Our Ref: BR/341/19/PL

**Town & Country Planning Act 1990 (as amended)
Town and Country Planning (Development Management Procedure) (England) Order 2015
Application for Planning Permission**

Development InstaVolt are proposing to install 2 rapid electric vehicle charging stations within the grounds of Co-op Bognor Regis. An existing parking area will become 2 EV charging bays, along with associated equipment.

Location 152-156 The Coop Hawthorn Road Bognor Regis

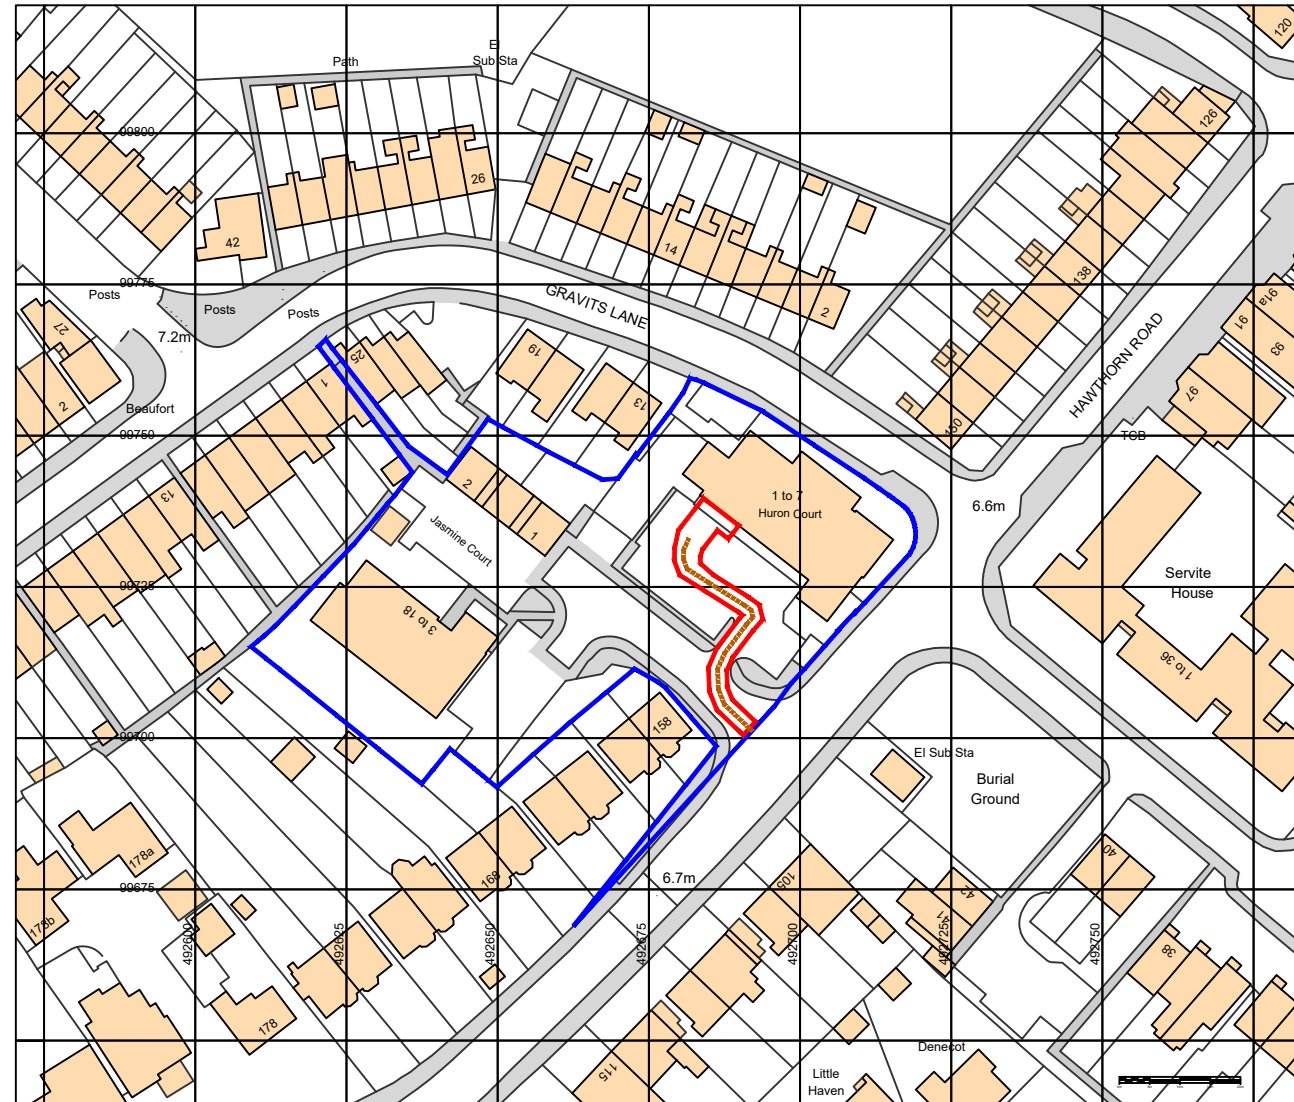
Location Plan: The access needs to be included within the red outline of the location plan.
